Our Ref: BN/18/22/DOC

Approval of details reserved by condition imposed under ref BN/17/21/PL relating to Condition Nos 3 - materials and finishes, 5 - Construction Management Plan, 9 - Energy Statement, 13 - surface water drainage, 14 - foul water disposal, 15 - Biodiversity Enhancement Plan.

The Cottage Highground Lane Barnham PO22 0BT

Arun District Council have decided to **REFUSE details reserved by condition for the following reasons:**

DRAWING TITLE:
PROPOSED DWELLING ADJACENT TO
EXISTING DWELLING
Proposed SWD Design layout

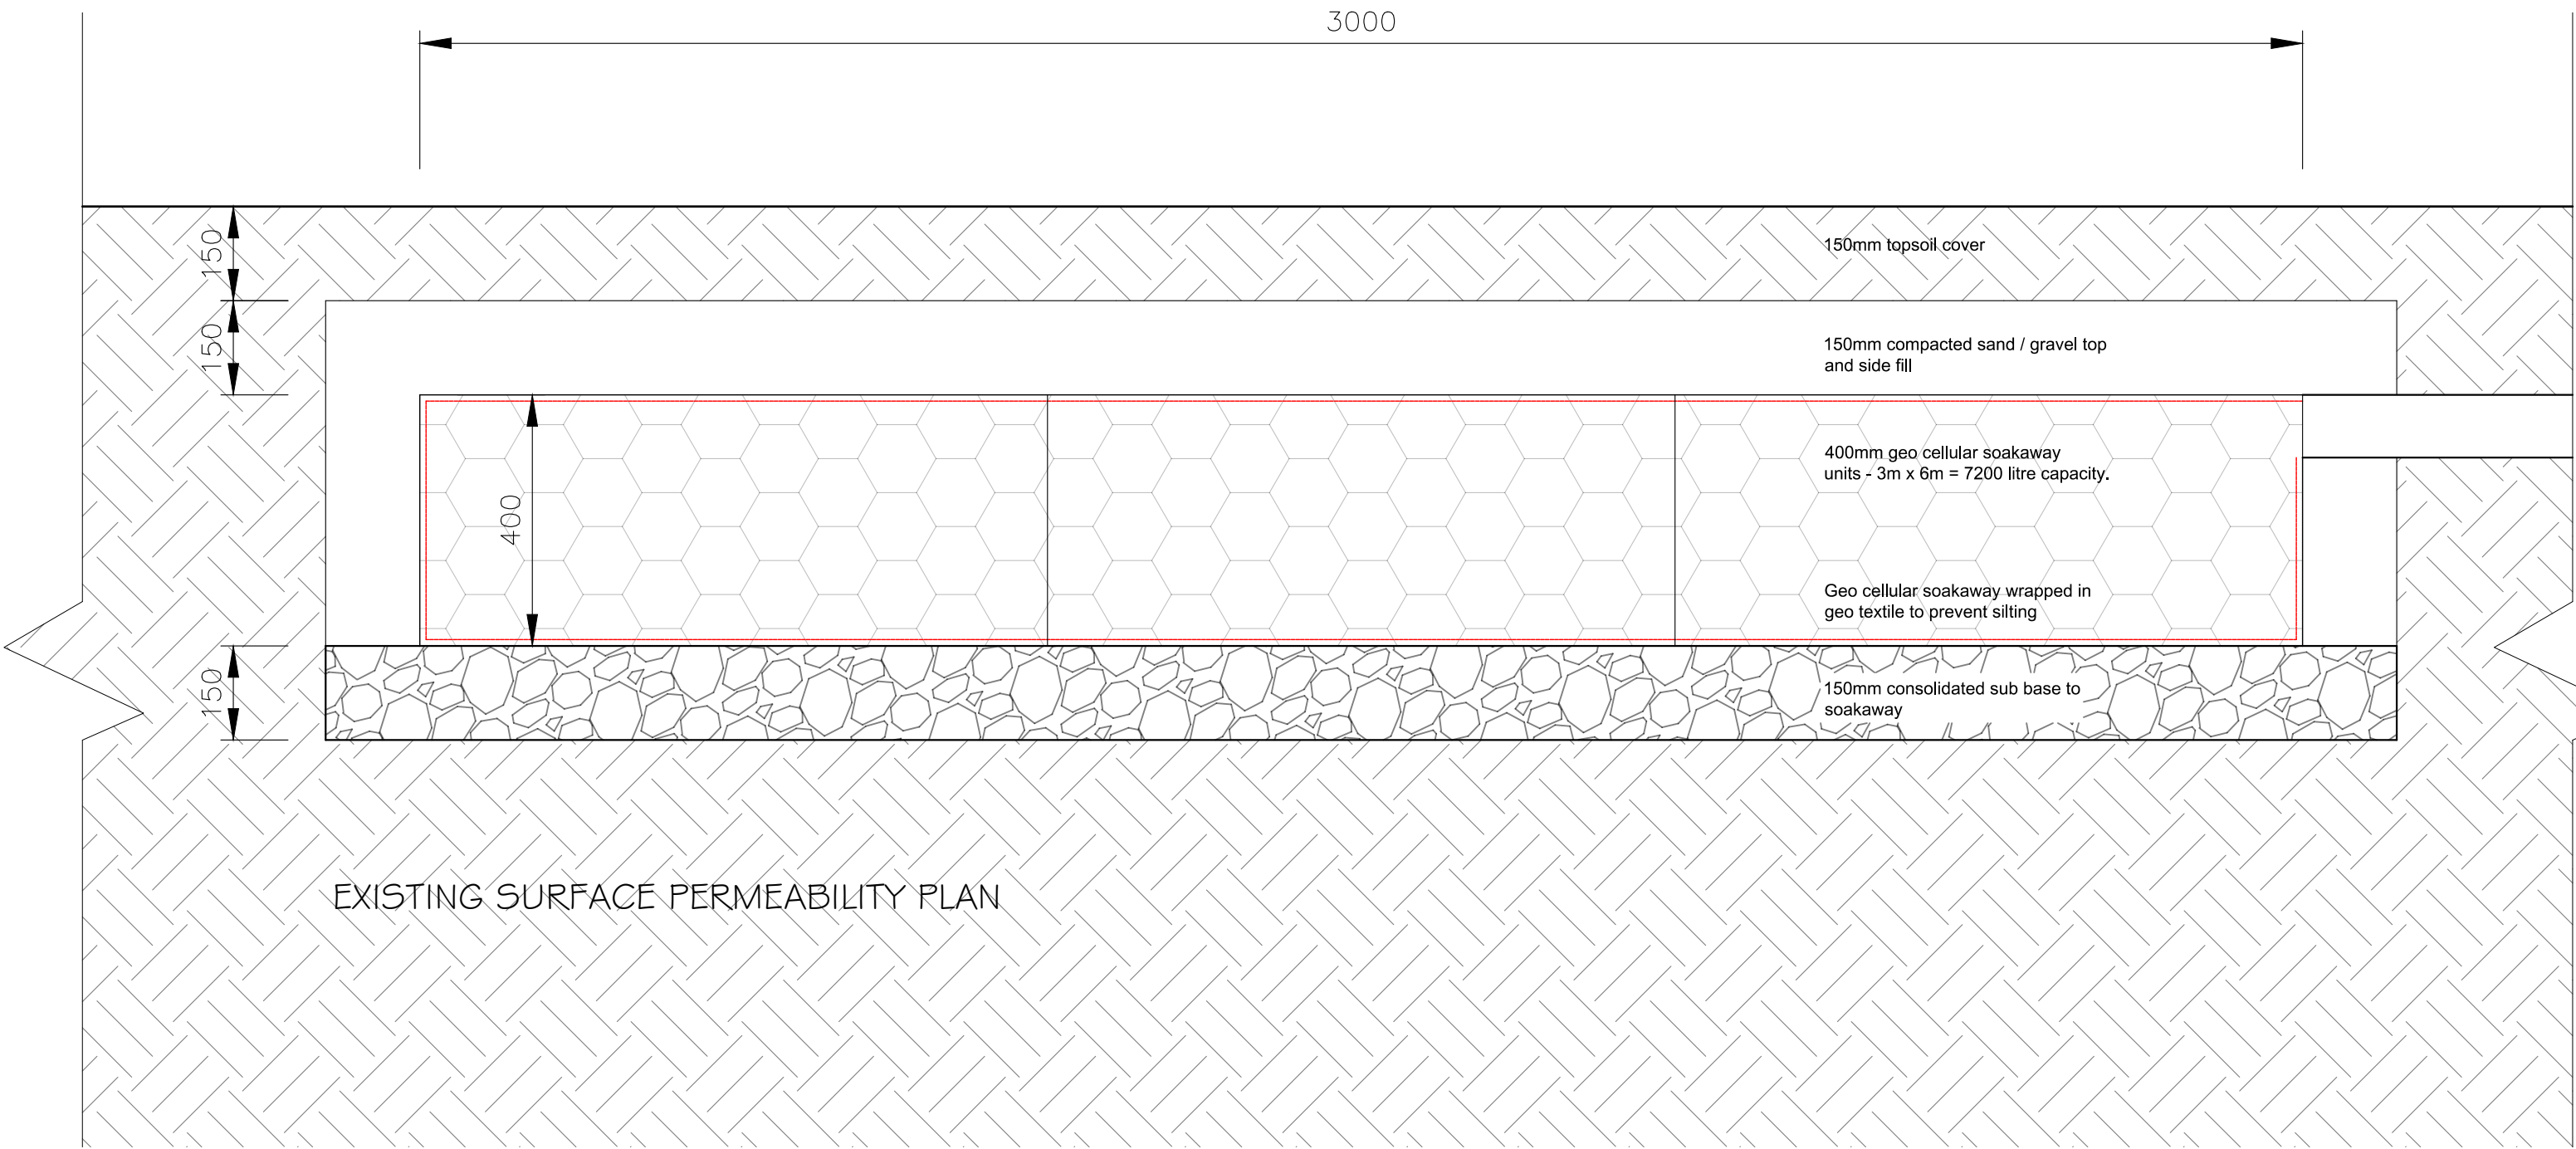
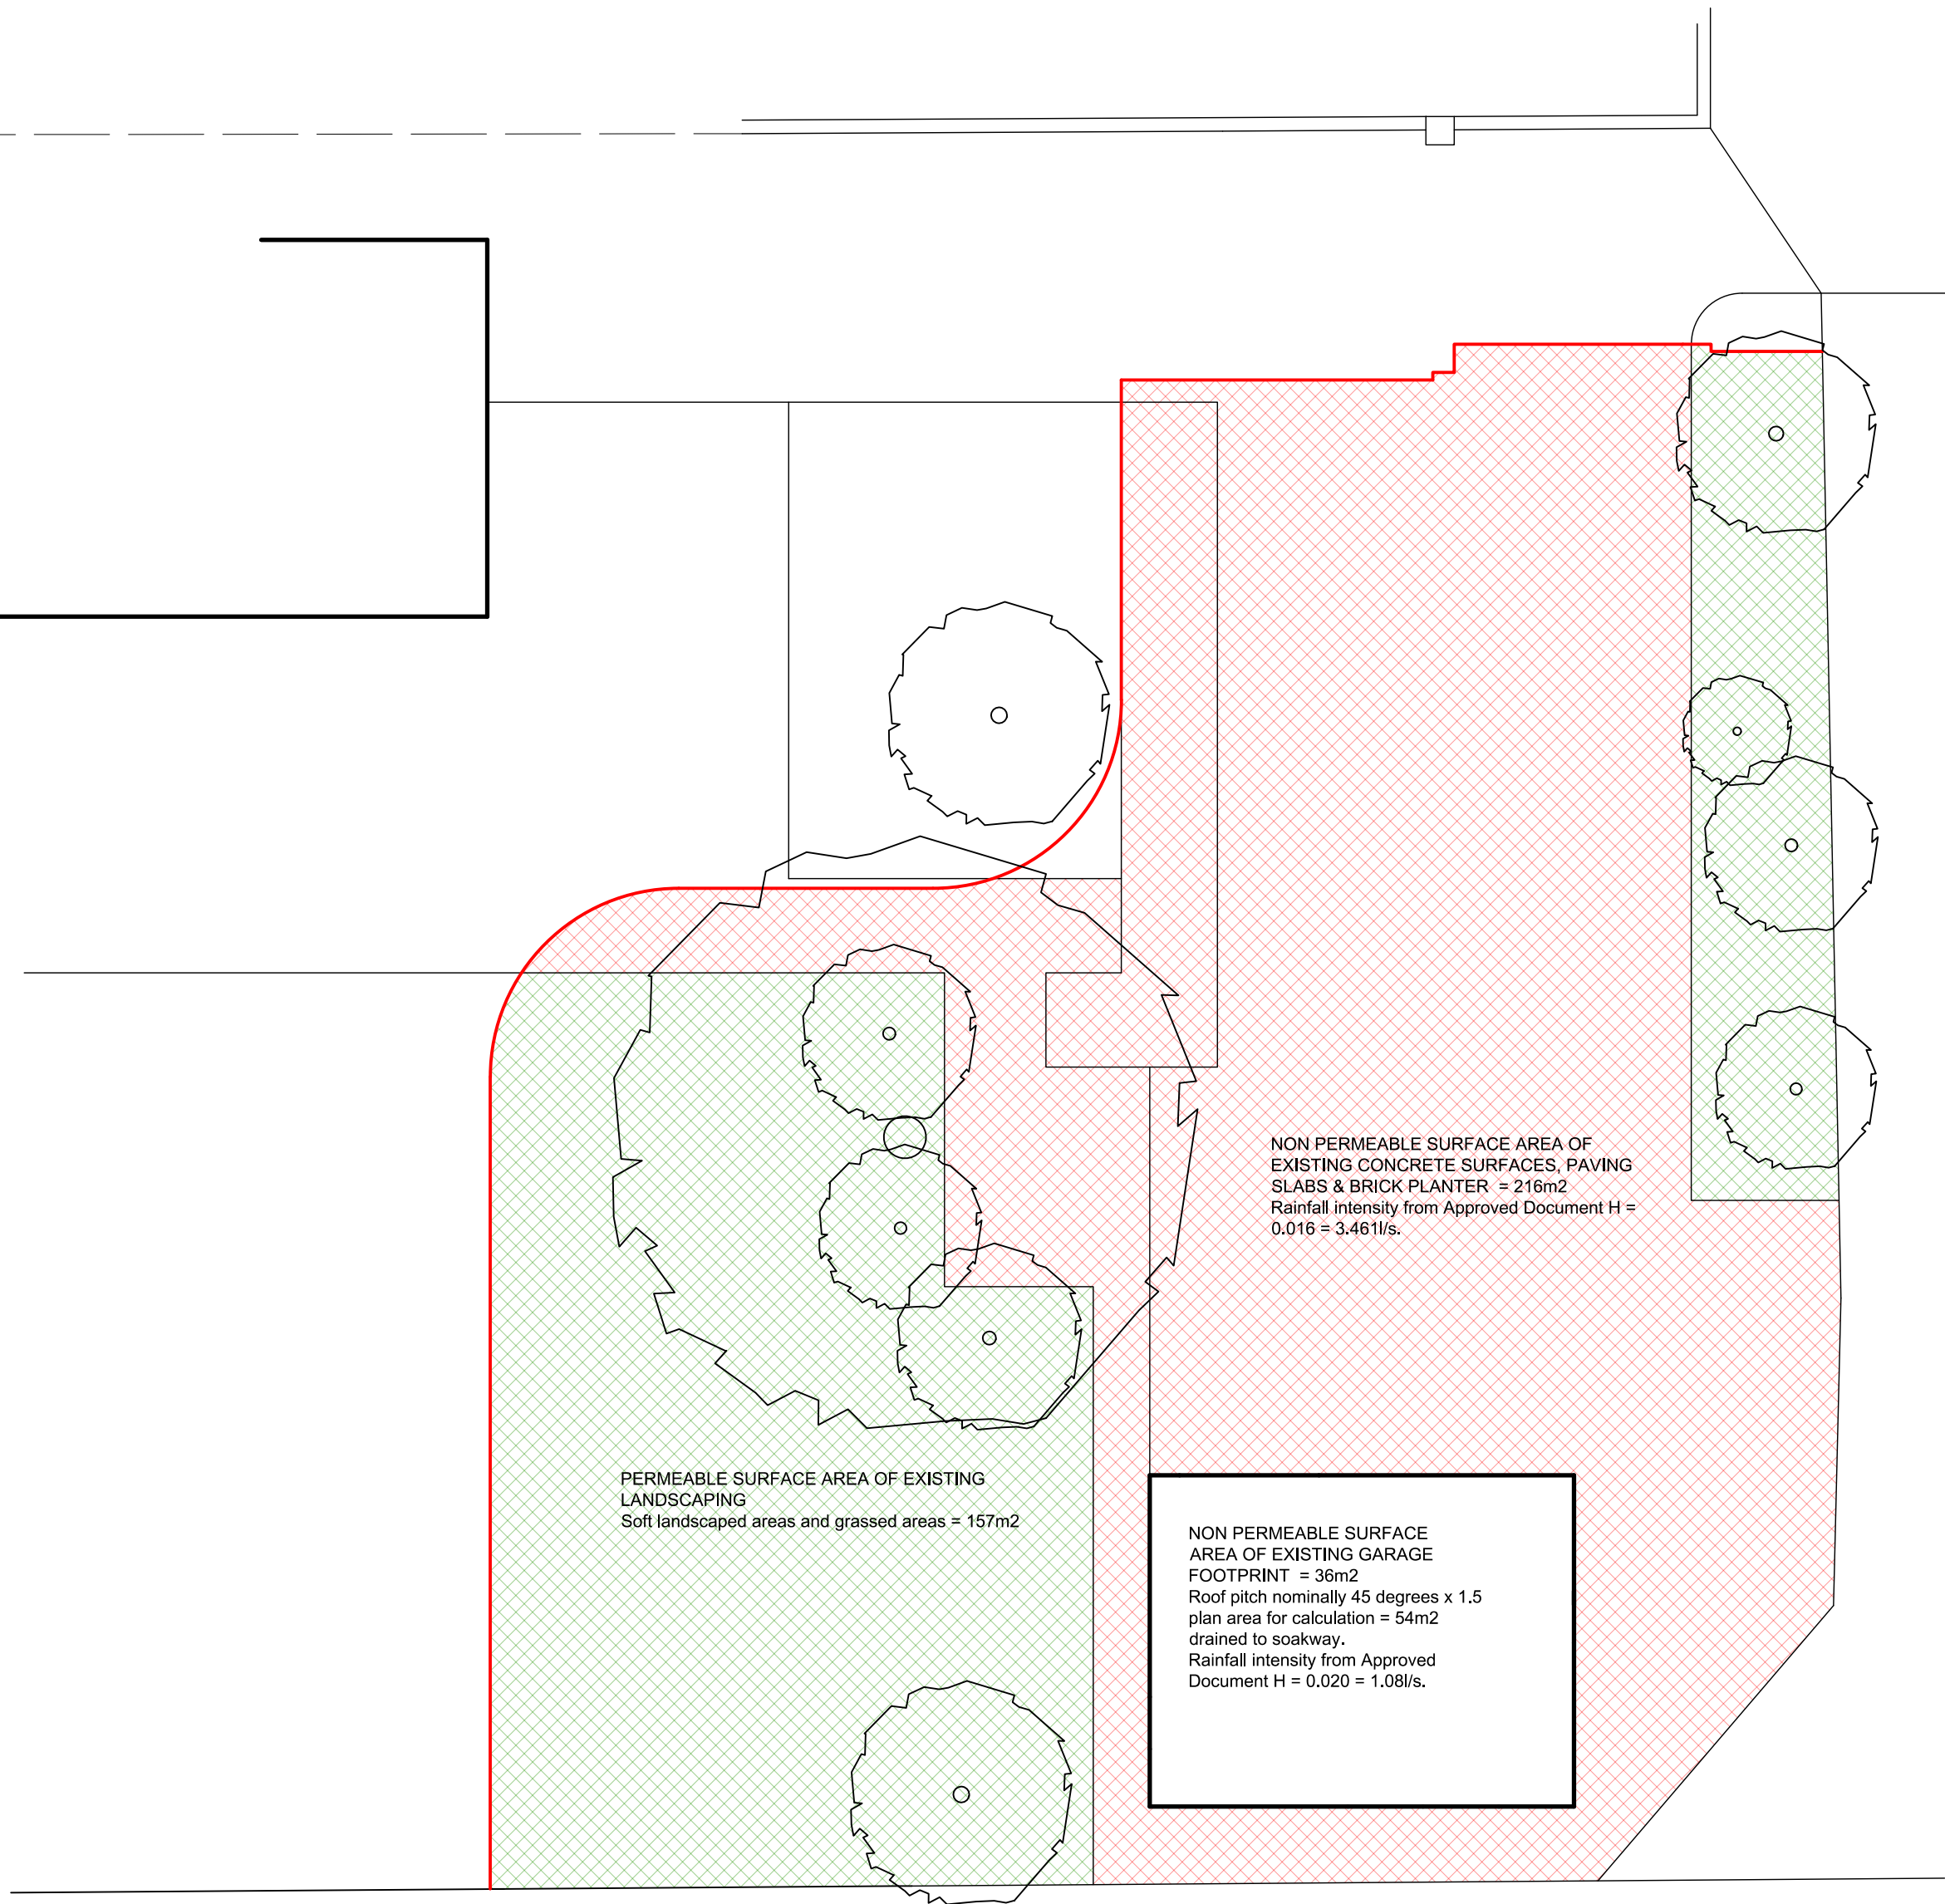
No formal winter groundwater monitoring has been undertaken or agreed. There are observations of groundwater which will prove to be useful.

Likewise, no winter infiltration testing has been completed. The applicant attempts to justify the lack of formal site investigations in the statement, however, both winter groundwater monitoring and winter infiltration testing are a stipulation of the Condition that they wish to discharge. These are not optional requirements.

1. Please specify the type of crate to be used - this must be suitable for vehicular loading at shallow depth.
2. Pipes labelled with pipe materials - or a note to state pipe materials if the same for all.
3. All inspection chambers to be labelled with a reference number, cover level, invert level and cover loading grade.
4. Add an inspection chamber to remove the pipe bend on the north side of the property.
5. Label catch-pits/silt traps with sump depths.
6. Provide construction detail drawing of pipe bed and surround, for shallow depths pipes are expected to be encased in concrete.
7. Provide construction detail drawing for inspection chambers.
8. Amend soakaway construction detail drawing to include vent location(s) and note invert level of incoming pipe. This should be above the level for the 1 in 10 year +40% event.
9. Provide a construction detail drawing for your permeable paving.
